15 June 2021
Our Reference: 2123

Planning and Listed Building Applications 21/01505/F and 21/01476/LB – Extension of existing boarding house through the reinstatement of part of the existing ruined coach house, the demolition of outbuildings, the erection of an extension and link structure (with associated alterations to Stone Hill House), insertion of internal wall, and associated works, at Stone Hill House, Stone Hill, Bloxham

Hylton Planning Ltd has been instructed by Mr Goulden of Ashwell Cottage, and Mrs Campbell of Ashwell House, Stone Hill, Bloxham to prepare this letter of objection to the above planning and listed building applications.

PROPOSED SOUTH ELEVATION
1: 100 @ A1

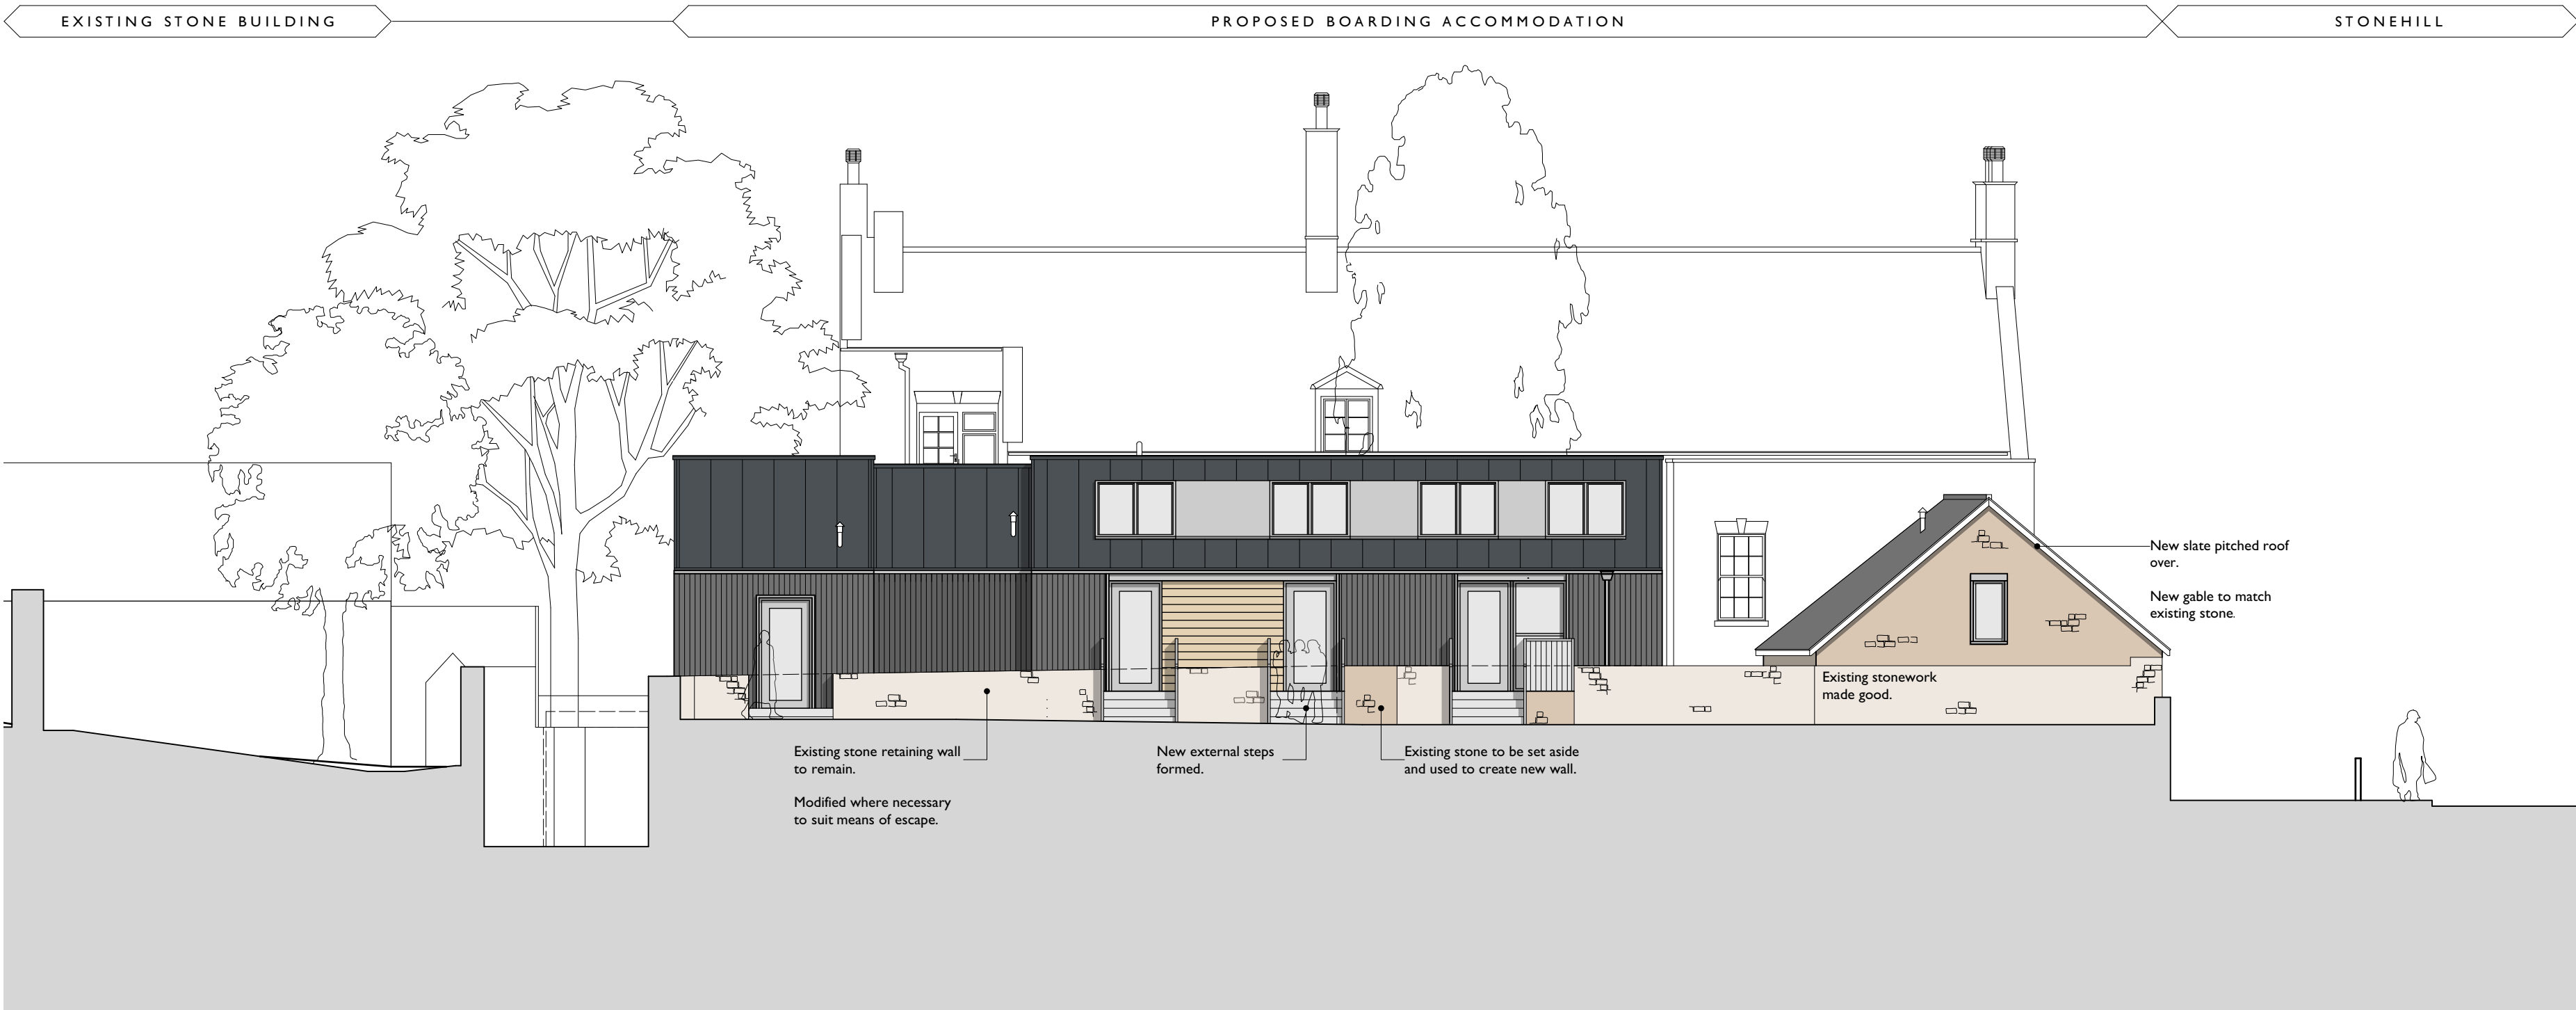
Whilst the former coach house/stable would be restored using ironstone to its elevations, it is proposed that the new pitched roof, which would run parallel to Stone Hill above the existing boundary wall would be covered in Aluzinc standing seam zinc roof sheeting. The same would be applied to the new two-storey block to the west, together with vertical and horizontal timber boarding and powder coated aluminium windows and doors. Paragraph 5.16 of HCUK's statement suggests that the use of zinc for the roofs will be in keeping with the slate on the main house (the roof is however covered in tiles as confirmed in the list description) but would have a more diminutive character, to maintain subservience (paragraph 5.27) and to retain a sense of primary and secondary spaces and structures, preserving historic hierarchy (paragraph 5.24). The Design Statement claims that the approach is to use traditional materials and form but with contemporary detailing, avoiding a pastiche aesthetic and enhancing the visual legibility between new and historic (paragraph 8.0).

In direct contrast, the standing seam zinc roof sheeting, timber boarding and aluminium windows which would be extremely prominent within the street scene, would appear as highly discordant and urbanising features which pay no attention to the simple palette of materials which is distinctive of Stone Hill. The development's approach to materials and detailing would be in direct conflict with saved Local Plan Policy C28 which requires the choice of external finish materials to be sympathetic to the character of the urban or rural context and that in sensitive areas, such as conservation areas, the use of traditional local building materials will normally be required, Local Plan Policy ESD15 which requires development to reflect or, in a contemporary design response, re-interpret local distinctiveness,

Turning to the design of the proposed development, aside from the zinc roofing already discussed, the building would be designed both with pitched and flat roofs, instances of vertical and timber cladding, glazed screens of varying sizes and windows of varying sizes and alignment, including a large projecting window which breaches the eaves of the roof, a window which wraps around the north eastern corner of the proposed building, a smaller window with horizontal emphasis, large rooflights on the western roofslope and glazed screens and doors with vision panels to the street elevation. Whilst the accompanying Design Statement addresses Visual Appearance and Massing at Paragraph 7.0, it does not explore or justify why the proposed visual appearance and treatment of the buildings are suitable within their context. Furthermore, HBC states that the design chosen for the gates is inappropriate for the listed building and conservation area; historic gates and doors do not have tall 'vision panels' (paragraph 3.14).

As proposed, the elevations appear as a complex mix of materials and treatments; the fenestration in particular introducing a wide range of styles, both on the building and within the historic wall facing Stone Hill, which does not reflect the distinctive simplicity and rhythm of Stone Hill House or the notation contained within paragraph 8.9 of the Draft Conservation Area Appraisal which states that houses [within the conservation area] are of substantial build and have simple detailing, based on medieval traditional and architecture. HBC states that the [proposed development] would be fully visible from the street and it would become an assertive modern intervention drawing attention to itself in the elevated topography of Old Park Farm and Stone Hill House (paragraph 3.28). It could not therefore be concluded that the development would be sympathetic to its rural context, contrary to saved Local Plan Policy C28. Furthermore, the design of the development would not contribute positively to the area's character or identity by creating or reinforcing local distinctiveness, nor would it integrate with the existing street in conflict with Local plan Policy ESD15. Stone Hill Views

Proposed Demolitions

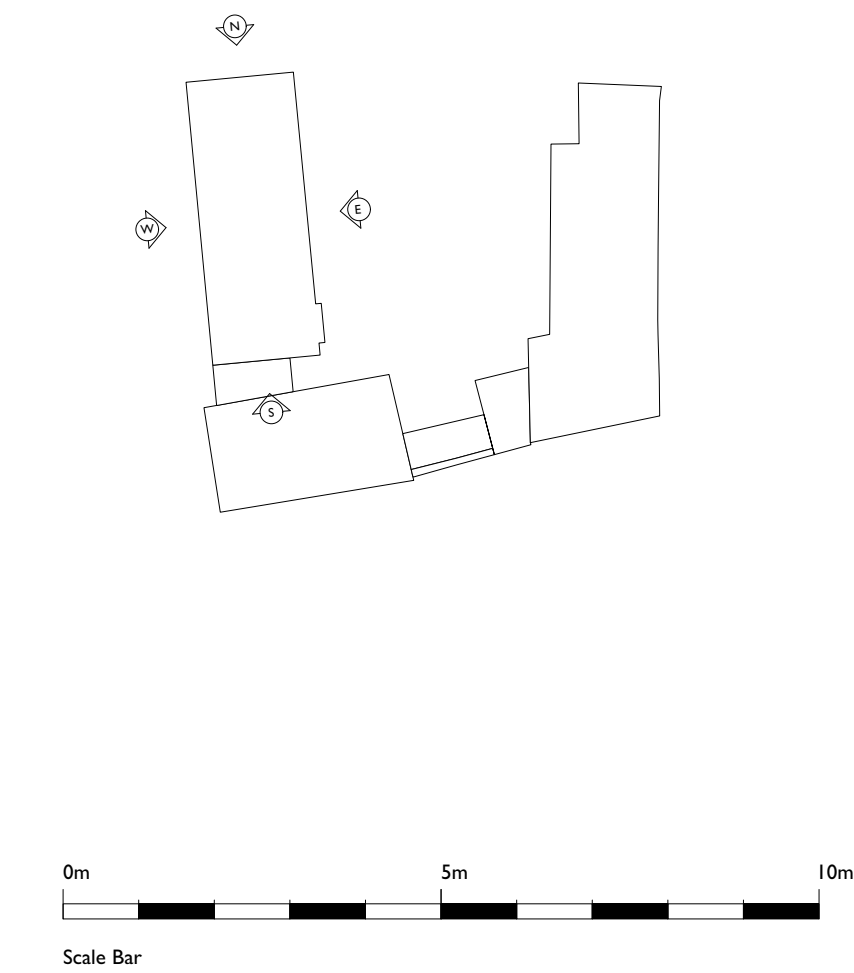
The Demolition Plan indicates the extent of fabric to be demolished, albeit that two elements of demolition are omitted from the plan. HBC's report states that a considerable amount of significant and listed fabric would be demolished which

HBC considers to be harmful as historic fabric is irreplaceable. The HBC report goes into further detail about the elements of demolition (see paragraphs 3.8 – 3.12), concluding that it would cause harm because listed, historic fabric would be removed or altered in ways that would diminish significance. It is also noted that much of the historic fabric to be removed is walling within the site, the removal of which is contrary to guidance contained within the Bloxham Conservation Area Appraisal (2007) which promotes the retention of boundary walls and gateways.
